Project Name: **Papi & Romano Builders Shop**
Project ID: #2014-211
Address: 828 Riverside Street CBL: 325 B008 001
Applicant: Rick Romano
Planner: Jean Fraser

On December 23rd, 2014 the Planning Authority approved with conditions a Level II site plan for the demolition of a garage and construction of a new 4534 sq ft woodworking and builders shop at 828 Riverside Street. The decision is based upon the application, documents and plans as submitted by Rick Romano and prepared by Whipple Callender Architects and Pinkham & Greer Civil Engineers as listed at the end of this letter. The proposal was reviewed for conformance with the standards of Portland's site plan ordinance.

Public Services Review Comments

Re: 828 Riverside Street – Proposed Woodworking Building – Rick Romano

2 SITE PLAN
SCALE: 1" = 10'

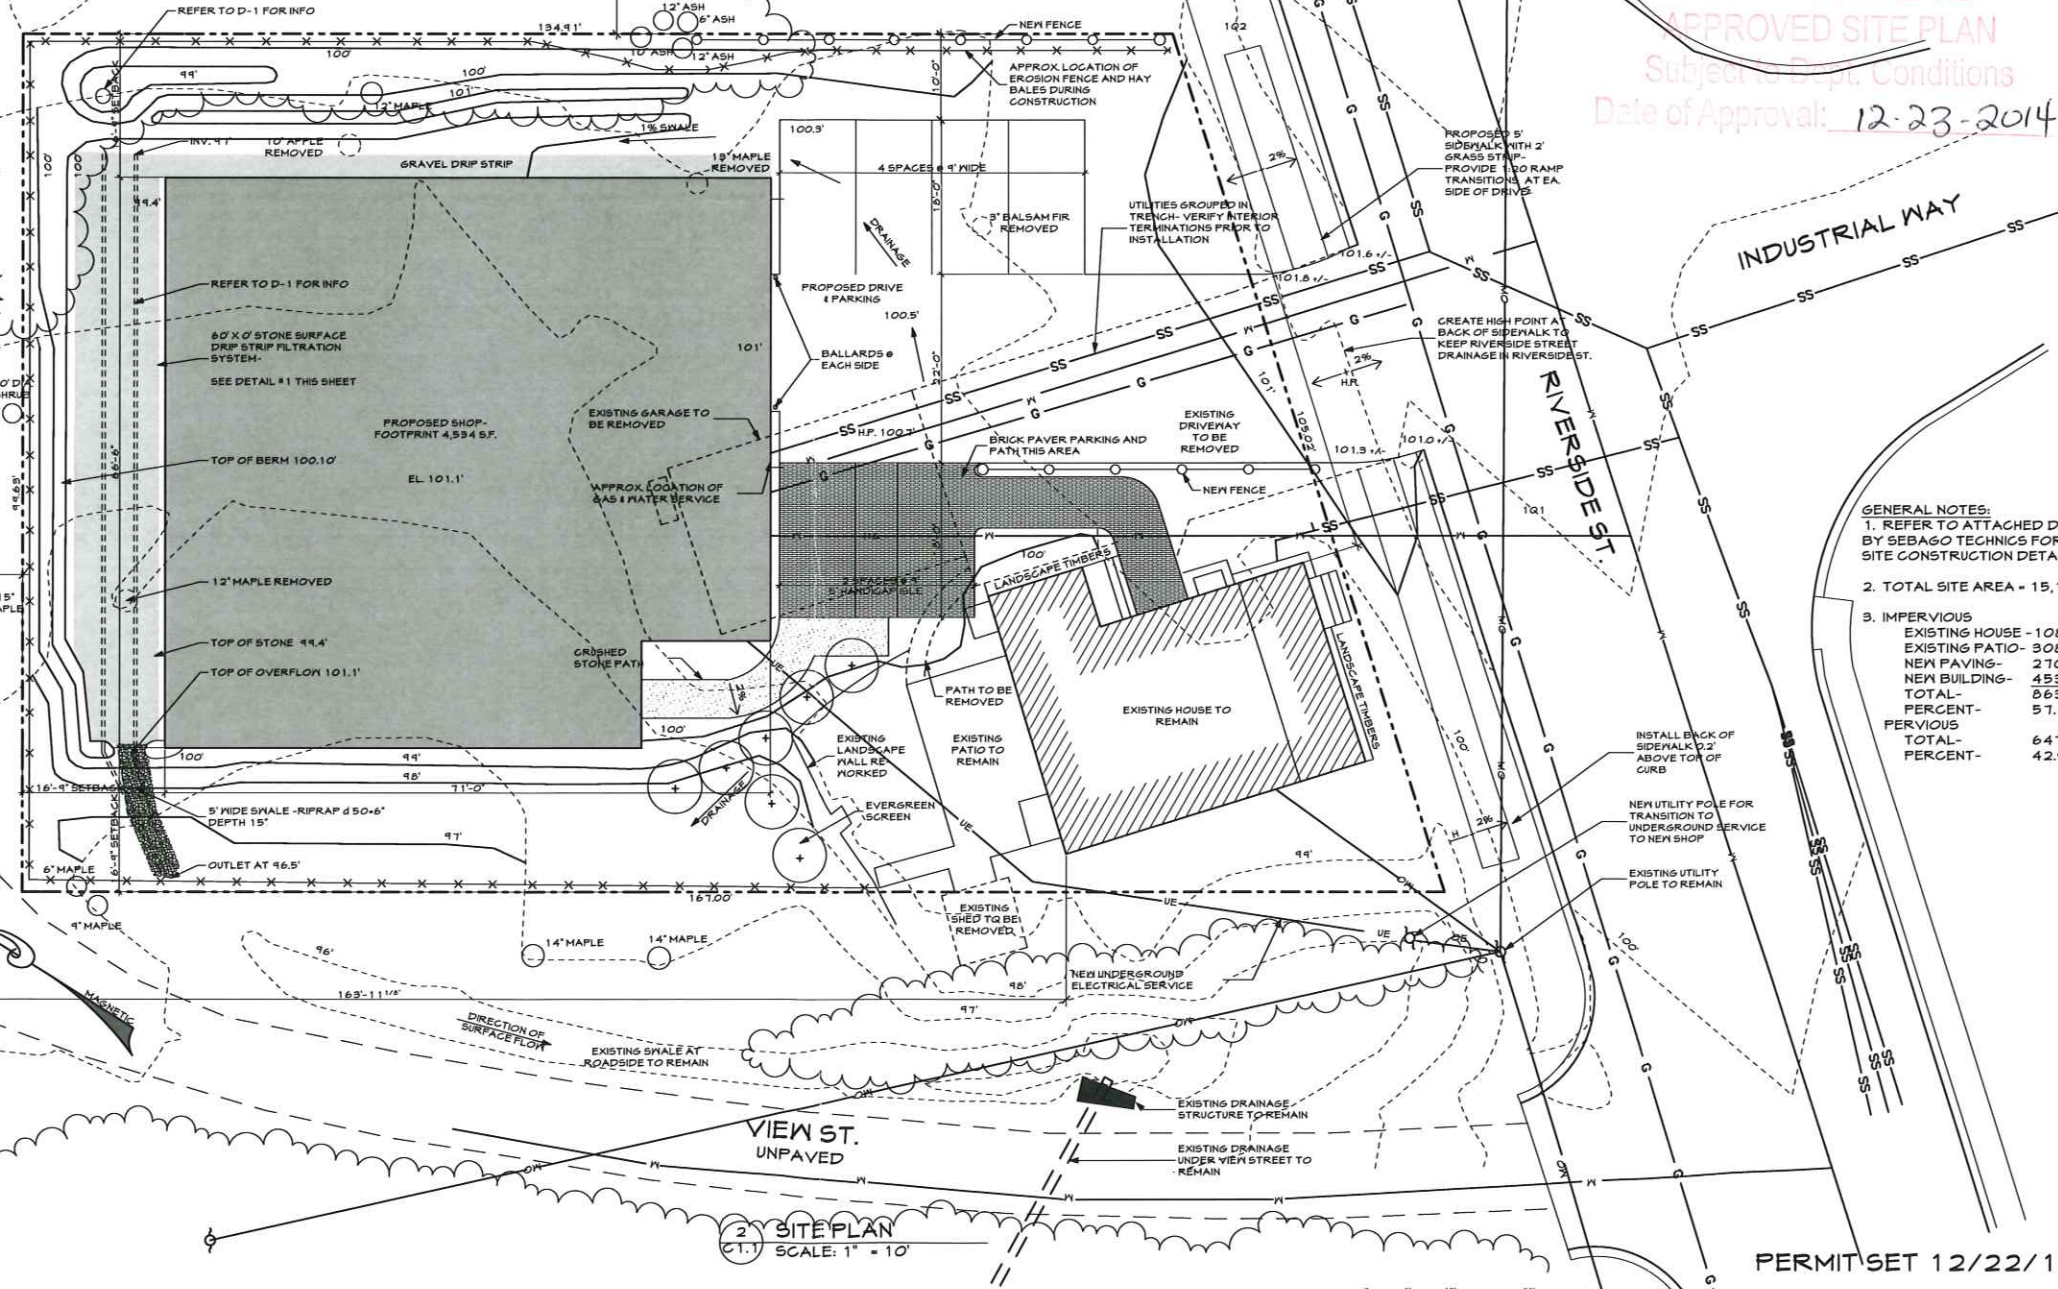
- Applicant current shows an approximate 10’ x 10’ shed within the View Street R-O-W. Applicant shall indicate that this shed will be moved onto the applicant’s property within the required 10’ setback line. Applicant has indicated they will move the shed.

- It would be beneficial to show a shaded area indicating that all three proposed utility trenches in the road will be repaired as one repair.
- Although a manhole is not shown where the sewer connection is proposed, it appears the applicant intends to connect the sewer lateral to a manhole. This practice is currently not allowed per the City’s Technical Manual. Our records indicate the sewer in the street is 8” PVC. We are requesting show the applicant’s sewer lateral connecting to the 8” PVC.

The service layout for the new building is not acceptable. Service taps and service lines need to be perpendicular to the main. We would suggest one service tap at the main in the location of the other utilities. You can then split into the domestic and fire just before the street line with service valves on both lines at the street line. We would be happy to work with you to come up with an acceptable service line layout.
